CITY OF ALBUQUERQUE

September 16, 2021

**Re: Fountain Hills Plaza Assisted Living
4051 Vista Fuente Rd NW
Request for Certificate of Occupancy
Transportation Development Final Inspection**
Engineer's/Architect's Stamp dated 11-19-18 (C12D003B8)
Certification dated 9-9-21

DRAWING:	DRAWN BY:	DATE:	SHEET #
201725-SITE.DWG	SDR	12-7-2017	1 OF 6

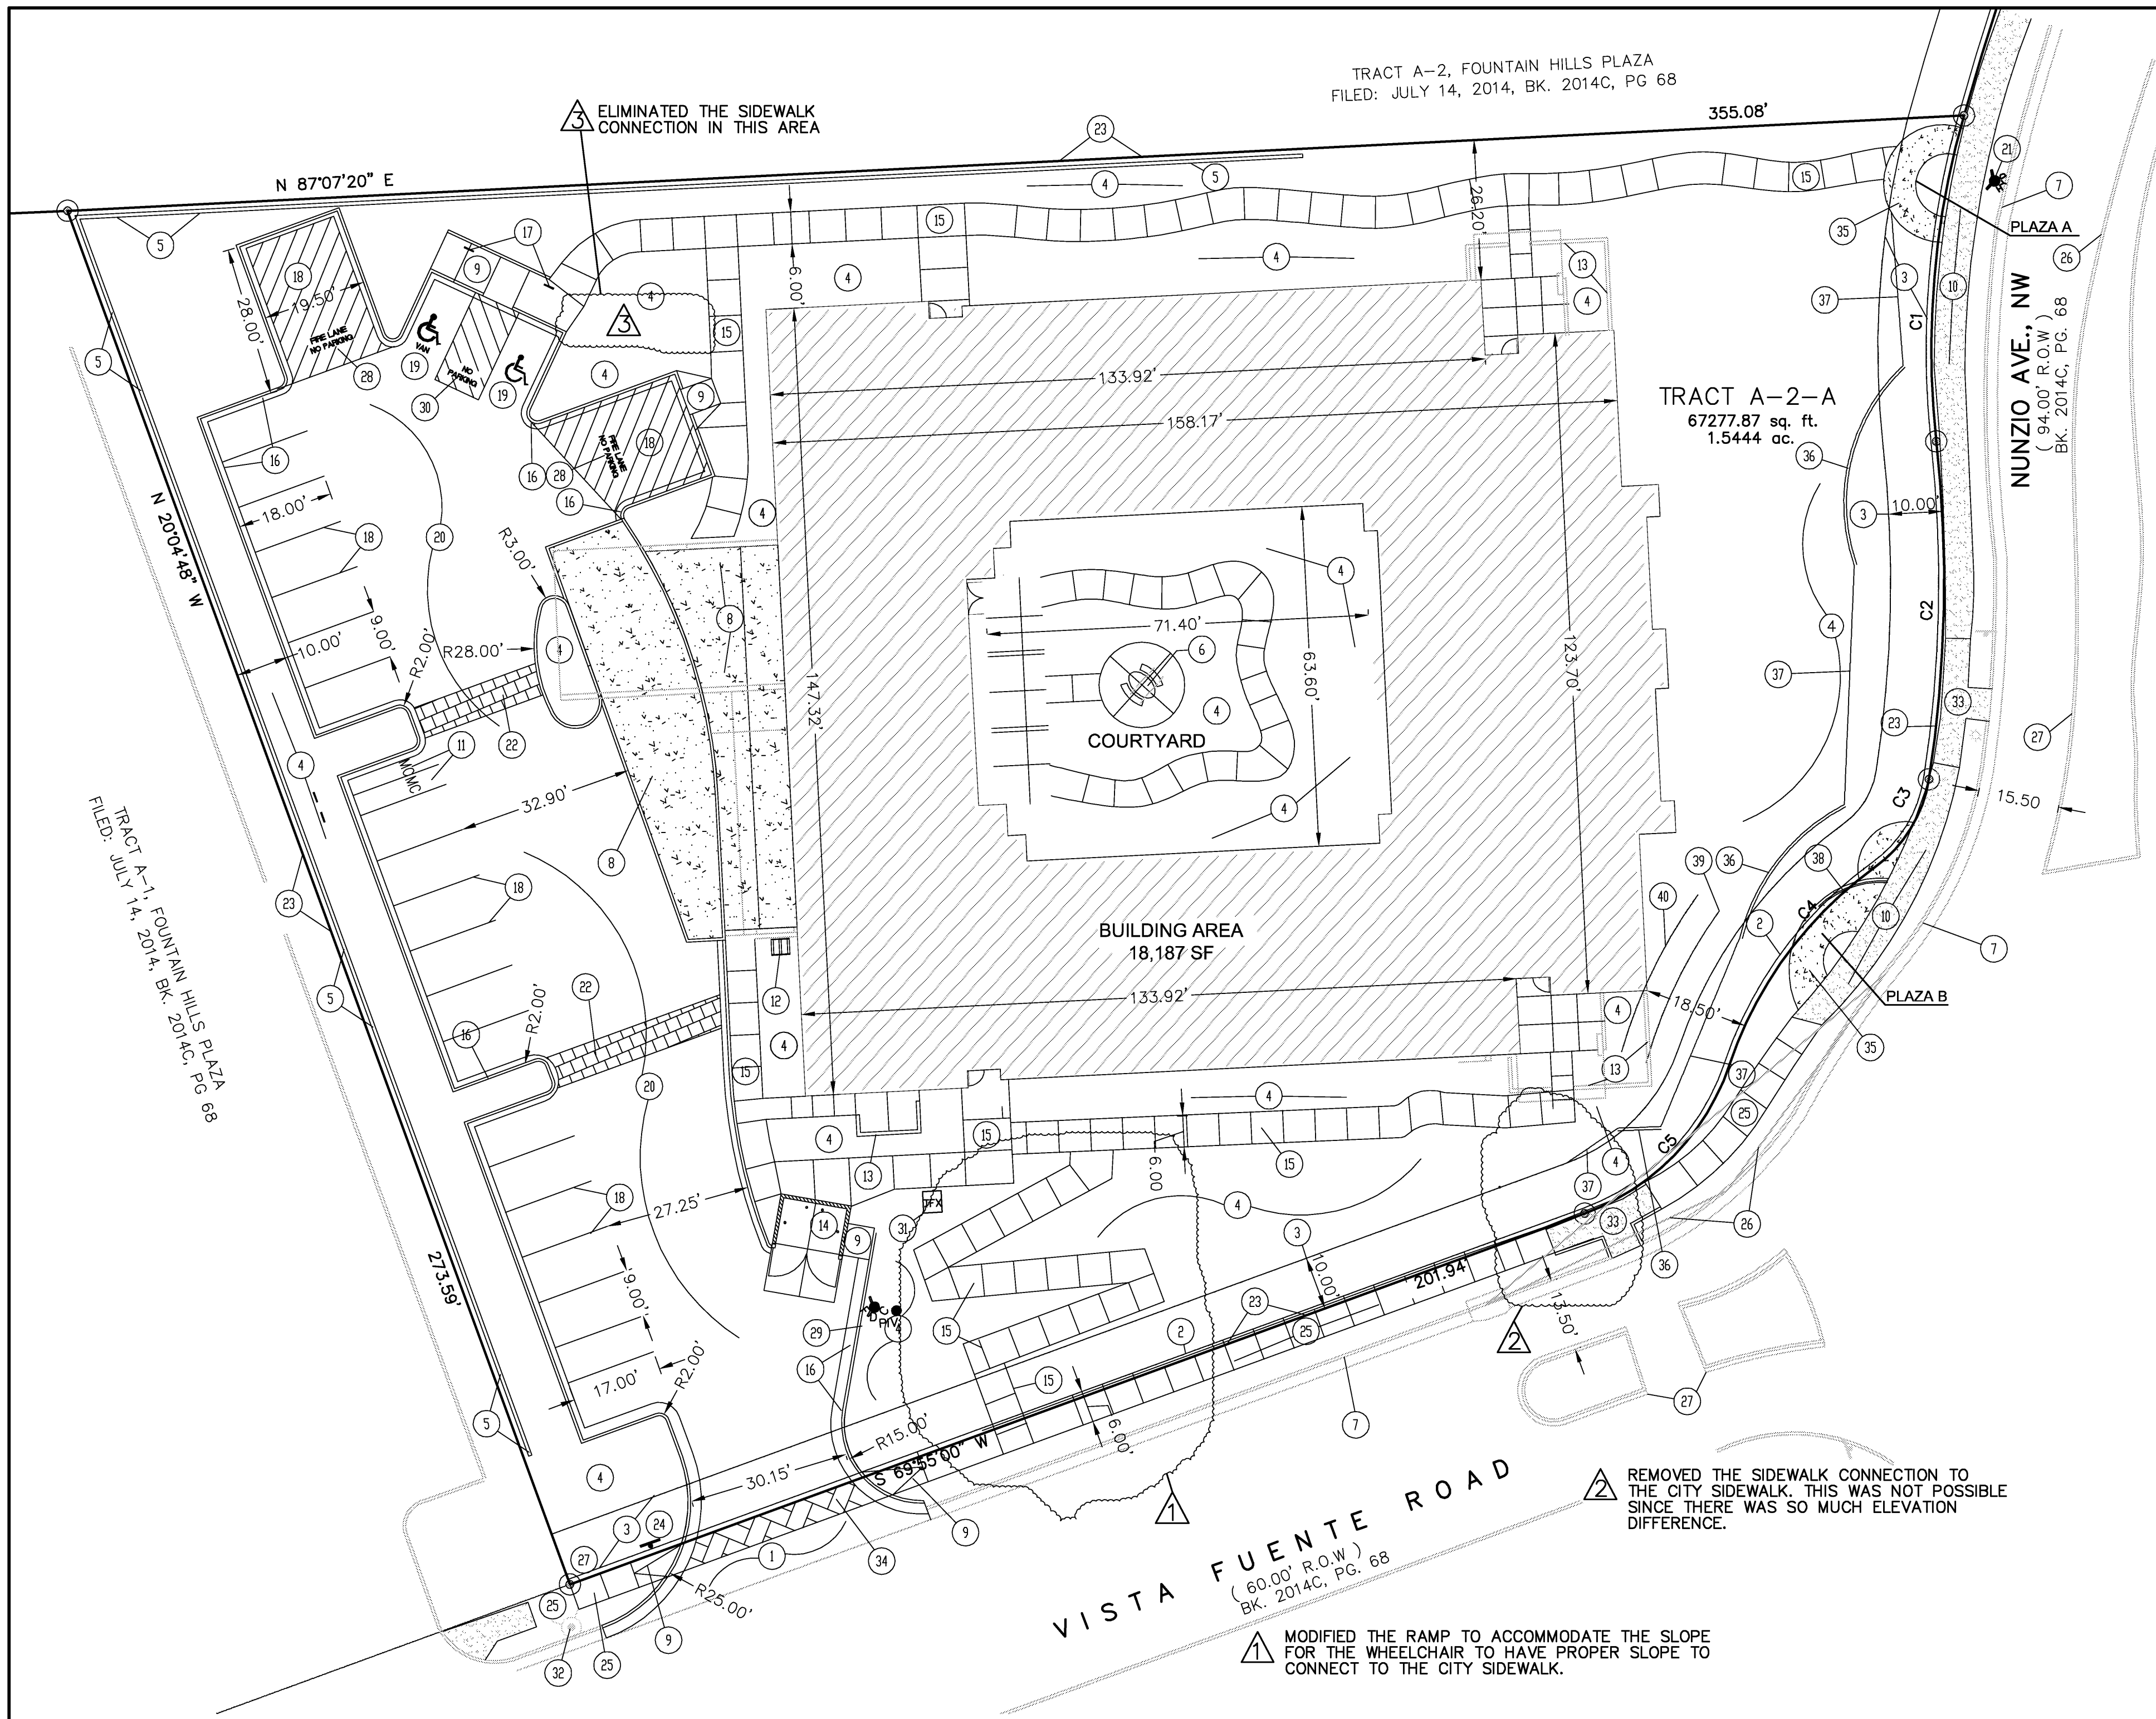
- Please install stop sign Keynote#24
- 6 foot ADA path from public right of way to the building entrance is not ADA compliant and is 5 feet in width on a portion of the path and is not complete to reach the Building entrance. (Max running slope 8% / Max cross slope 2%)
- Please redline plan to reflect the changes on the 6 foot ADA pathway from sidewalk to building entrance.
- All ADA ramps in public right of way have lips greater than ¼ inch. Please shave lips for a smooth transition onto the public sidewalk.
- Add ADA signs.
- Complete floor pavement markings and remove construction equipment and debris from site.

1. The approved and stamped Site Plan for Building Permit with changes drawn in red.
2. Transportation Certification letter on either the plan or applicants letterhead.
3. A Drainage Transportation Information Sheet (DTIS)
4. Send an electronic copy of your submittal to PLNDRS@cabq.gov.
5. The \$75 re-submittal fee for log in and evaluation by Transportation.
